Contact Officer: Matthew Salamone
Our Ref: D05699343
30 April 2025

Subject: UNSW Building E25 Biolink (SSD-73456206).

Thank you for the opportunity to comment on the State Significant Development Application for the UNSW Building E25 Biolink (SSD-73456206) – “Partial demolition of the UNSW E25 Biolink building, earthworks, extension of the existing building, internal upgrades and facade works”.

GENERAL ARRANGEMENT ROOF PLAN

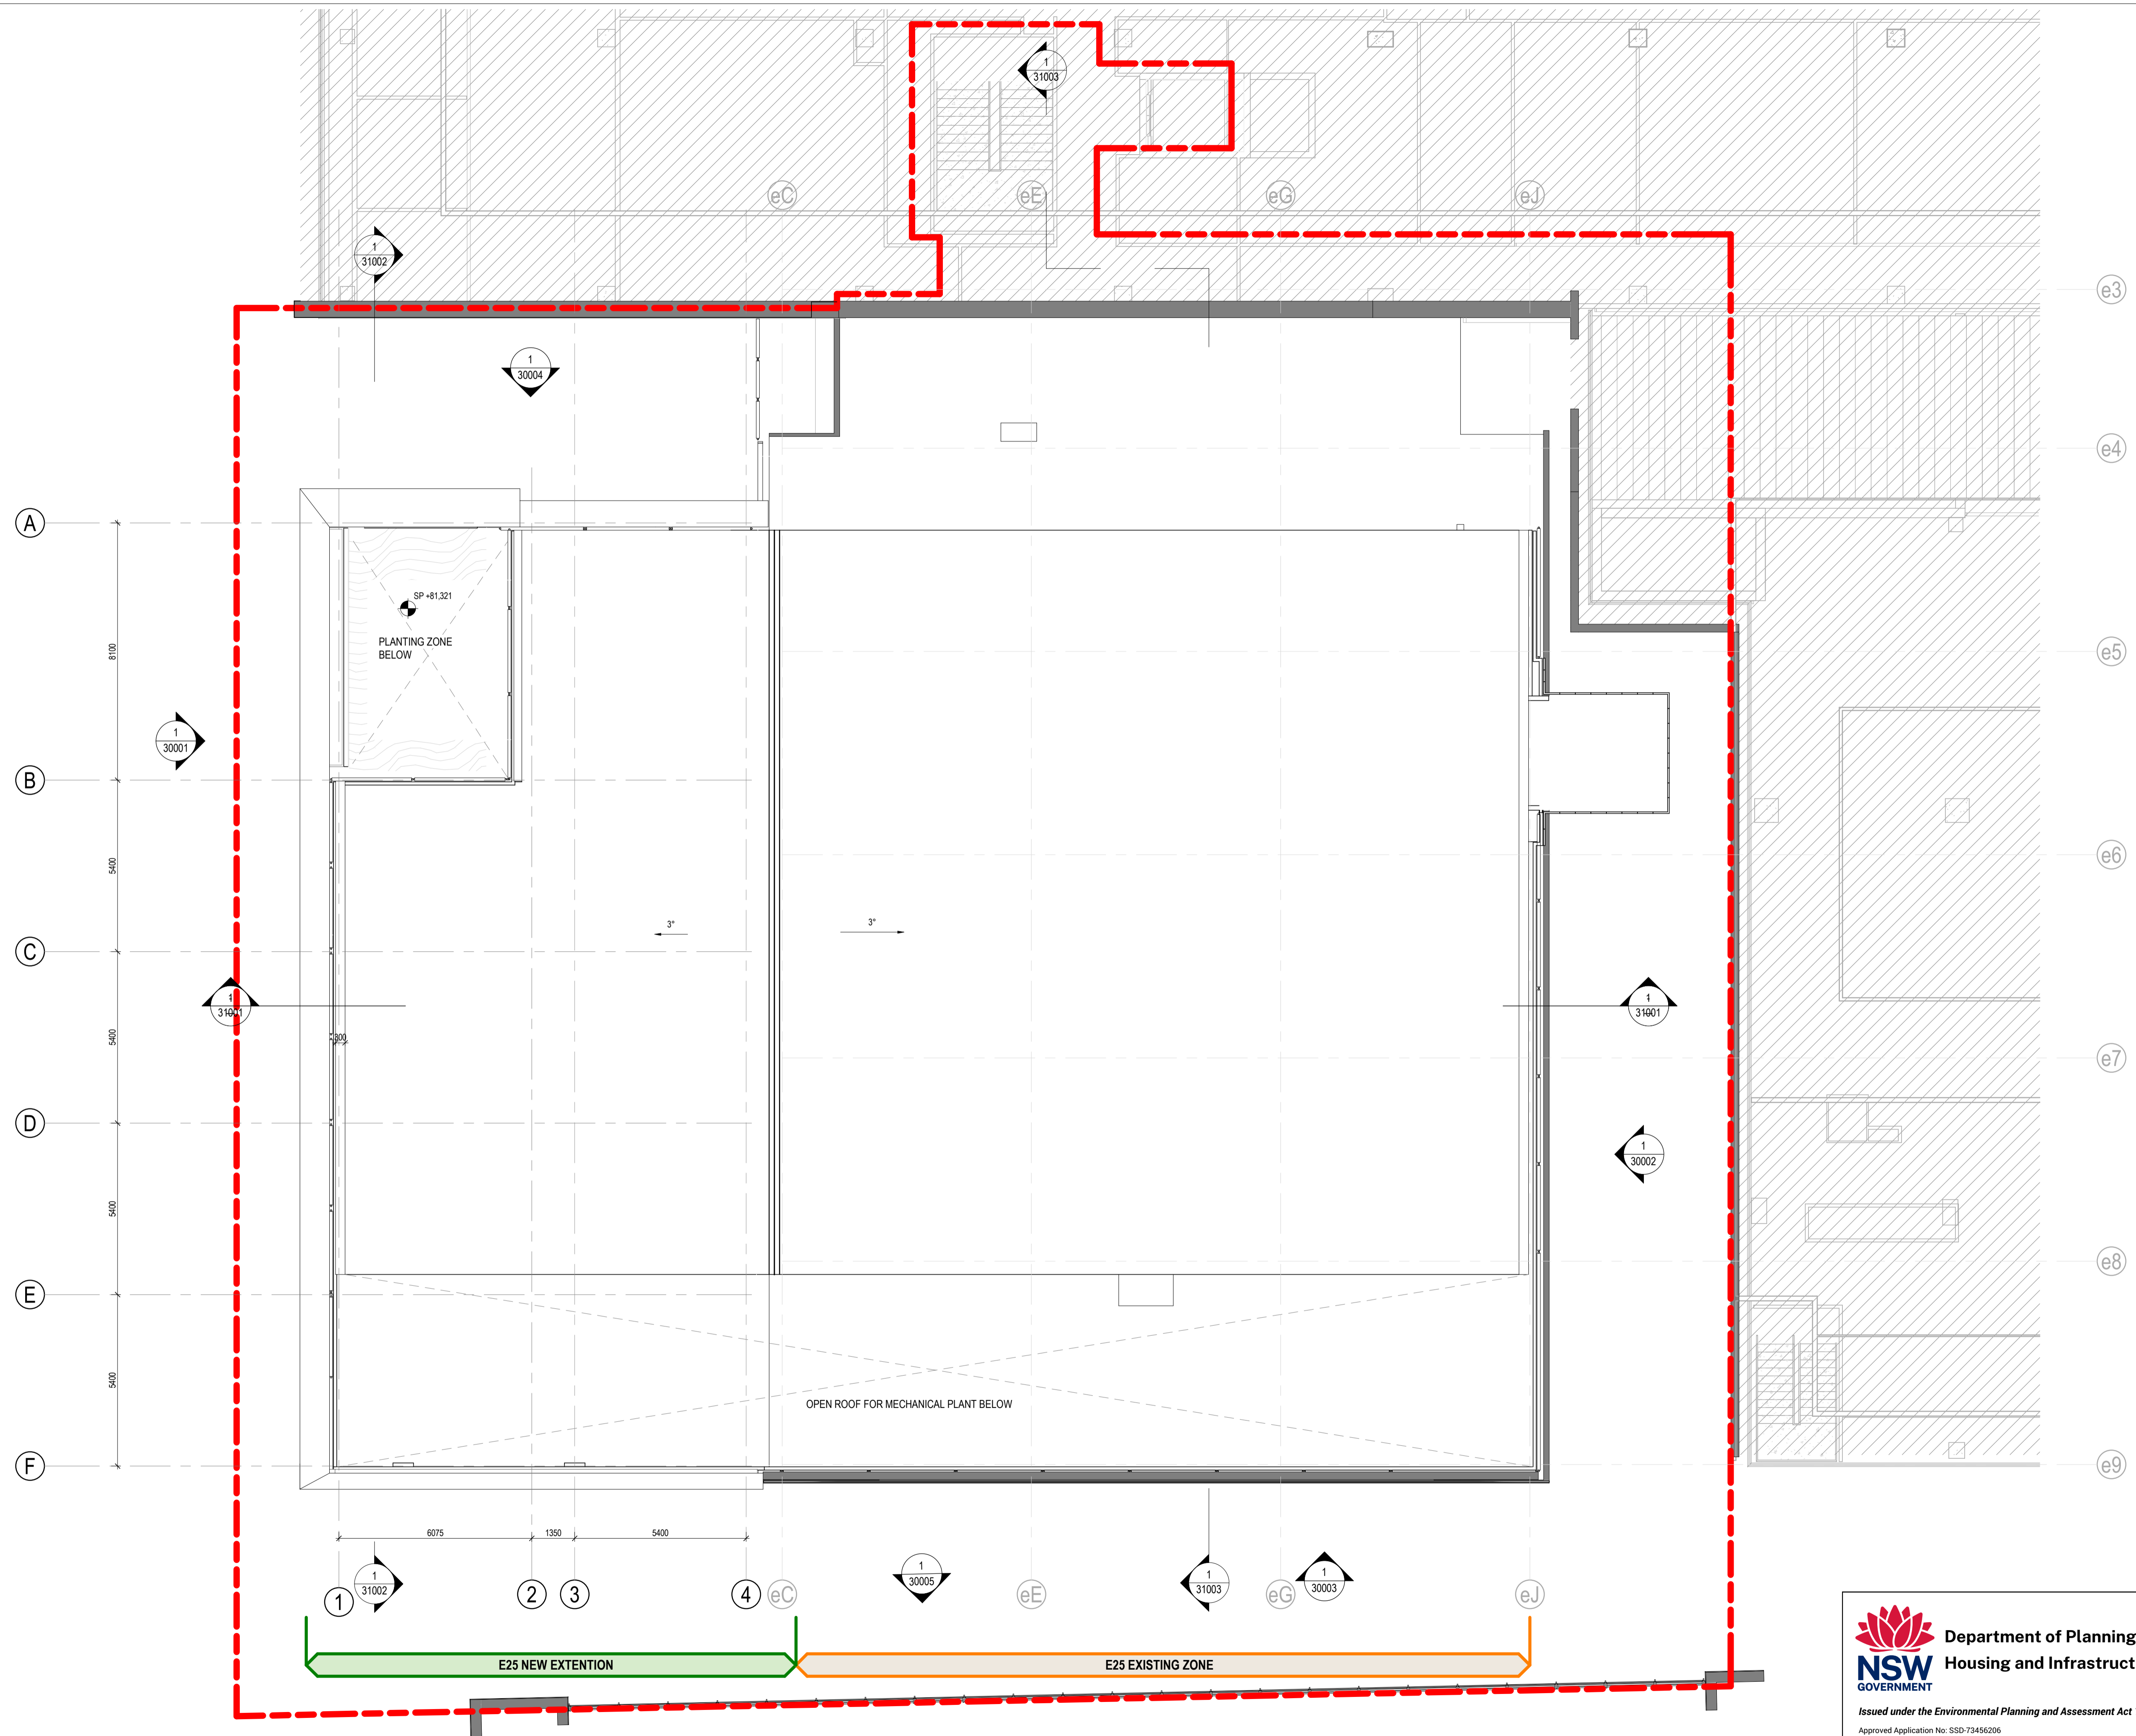
4. Given the location of the building within the Campus, Council concurs that there will be minimal additional neighbouring impacts in relation to overshadowing. It is noted that a variety of plant components are proposed to the roof of the building including a diesel generator and the storage of a number of lab gasses. Council therefore makes the below recommendations for consideration in the assessment and to be applied to conditions of consent where relevant.

- To mitigate dangerous goods to the plant area that a solar back up power system be investigated as an alternative to the proposed diesel generator. This would have added ESD benefits and lower operational/maintenance costs, with the presence of an existing solar panel array included in the exiting proposal;

PURPOSE OF DRAWING
GENERAL ARRANGEMENT LANDSCAPE PLAN
DRAWING TITLE

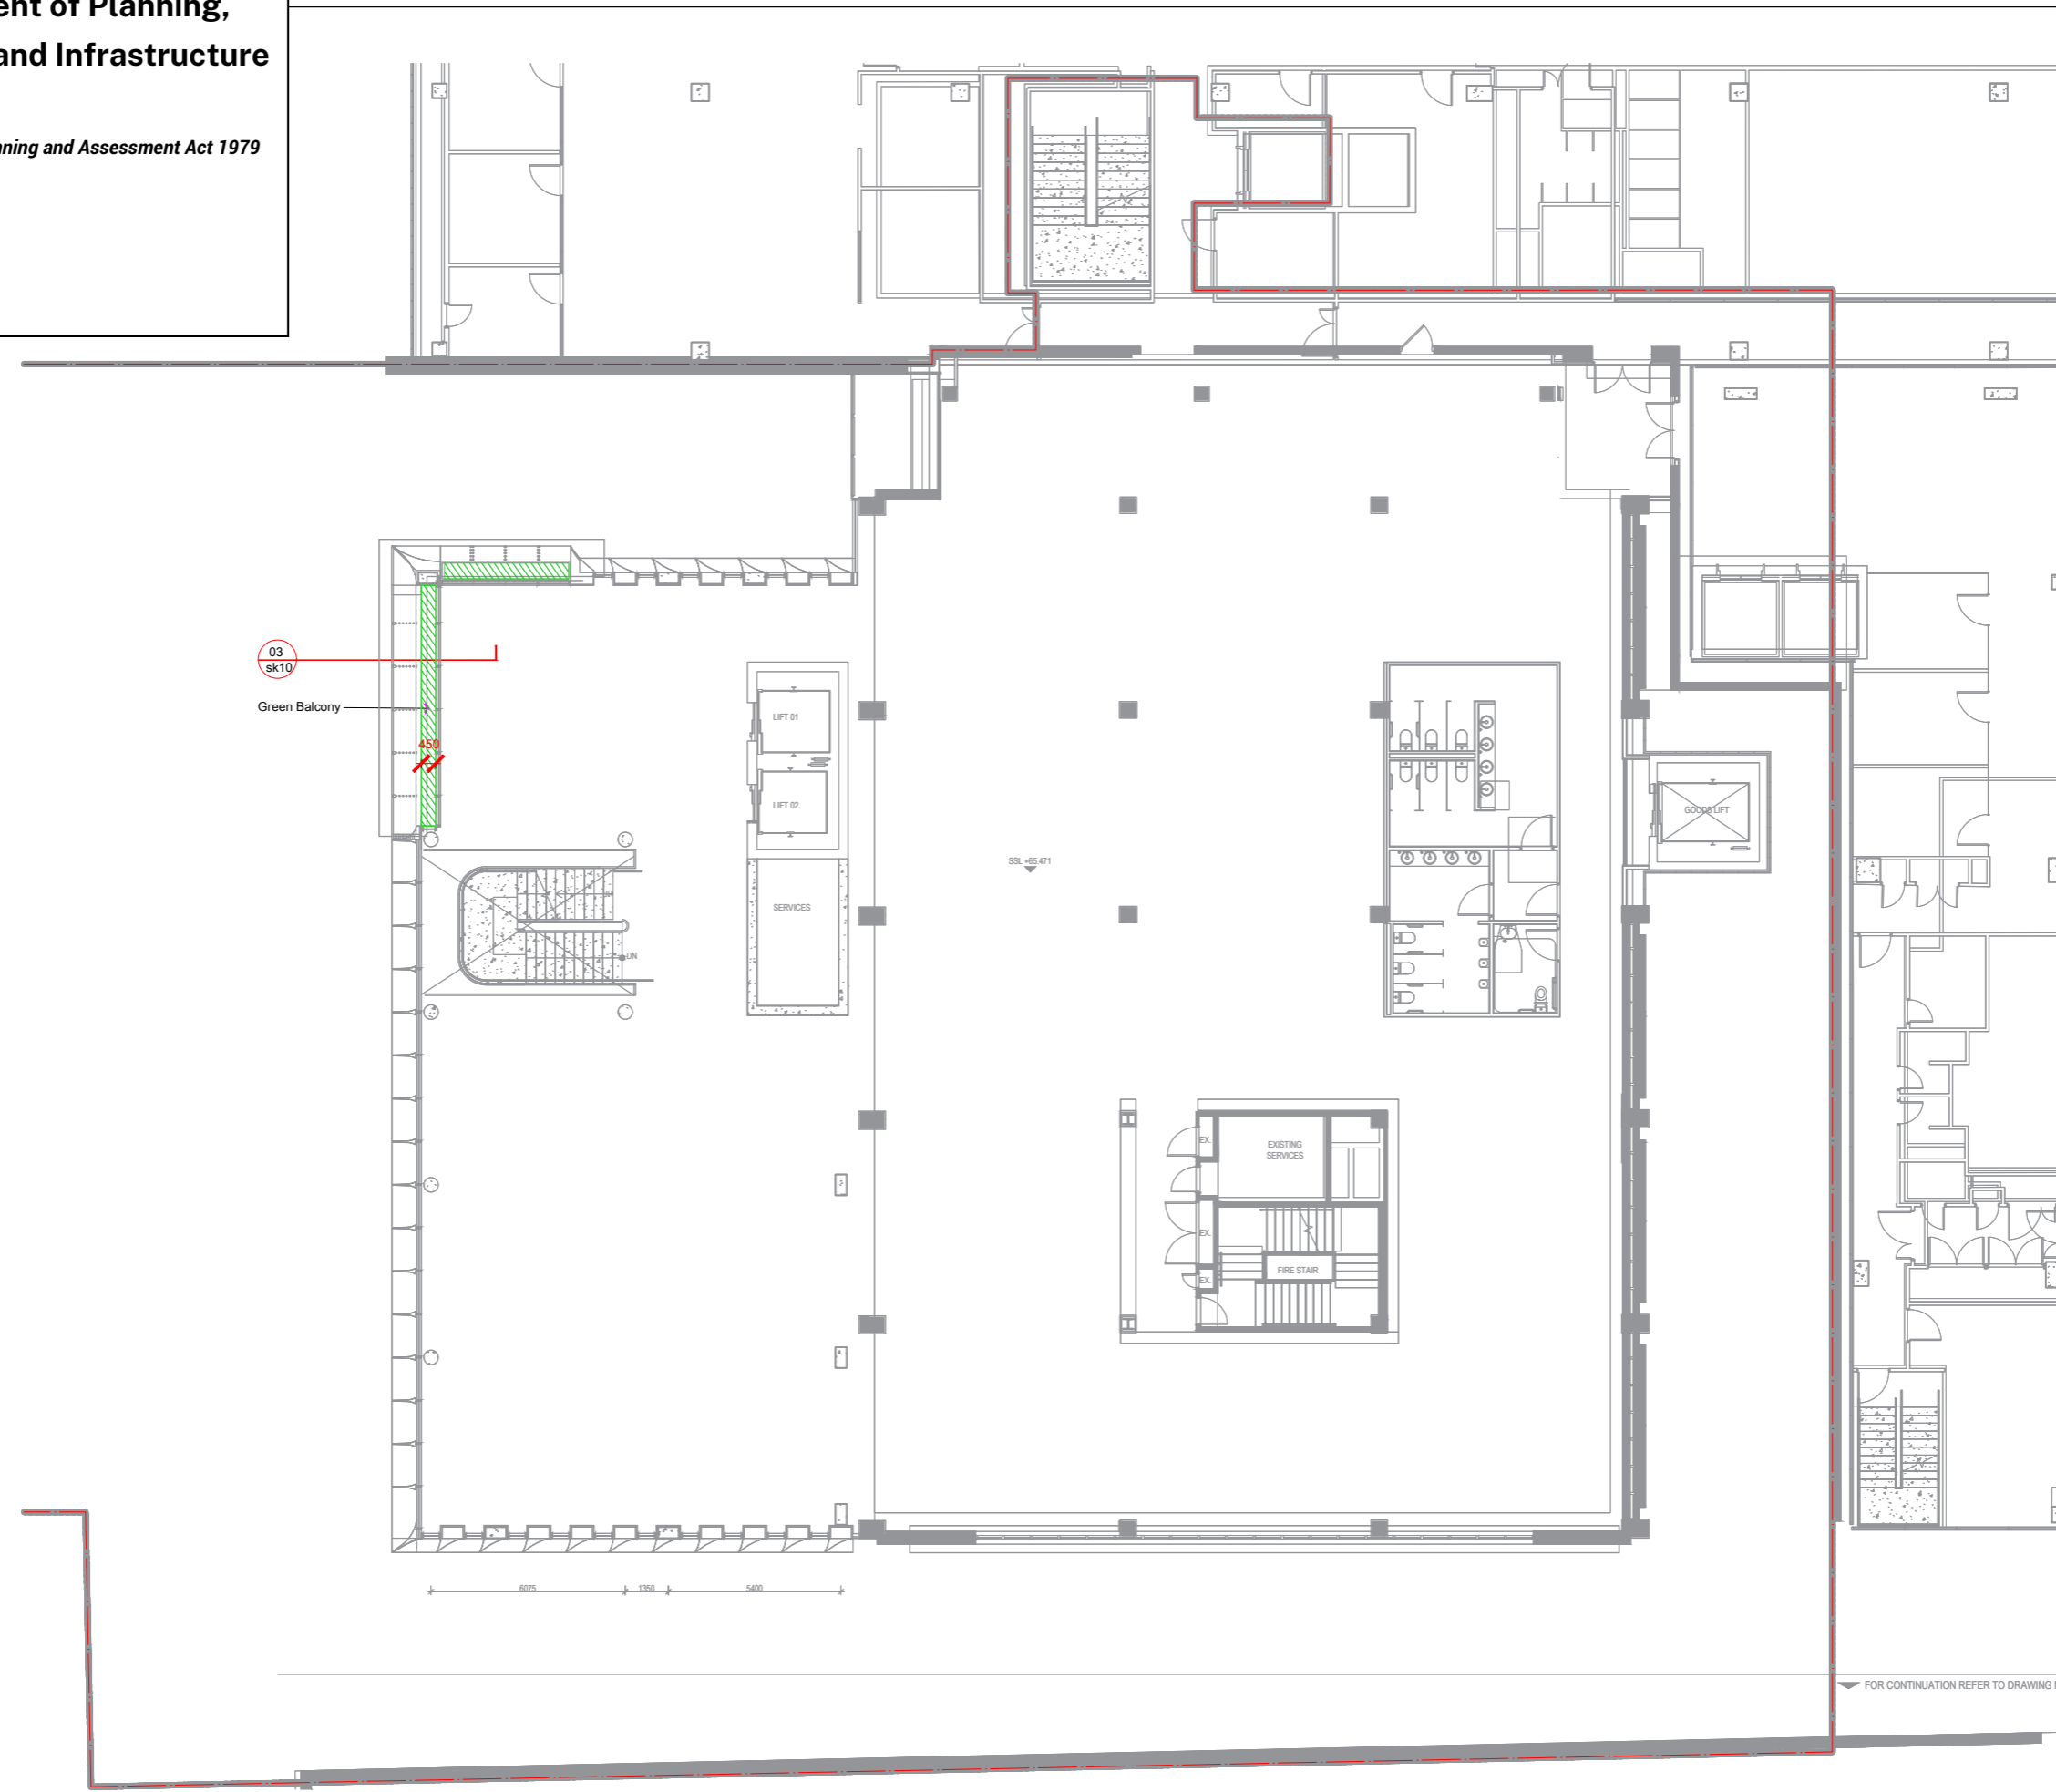
13. The proposed landscaping scheme whilst incorporating a good selection of natives, should be amended to provide an increase in the overall level of soft landscaping to improve biodiversity and greening on the campus.

14. It is noted that the proposed building has a strong interface with Chancellery Walk and therefore the design should protect and enhance vistas along Chancellery Walk as outlined in Part E2 of the Randwick DCP 2023. Similarly, legibility of the entire Chancellery Walk could be enhanced with significant planting that provide a strong landscaped edge.
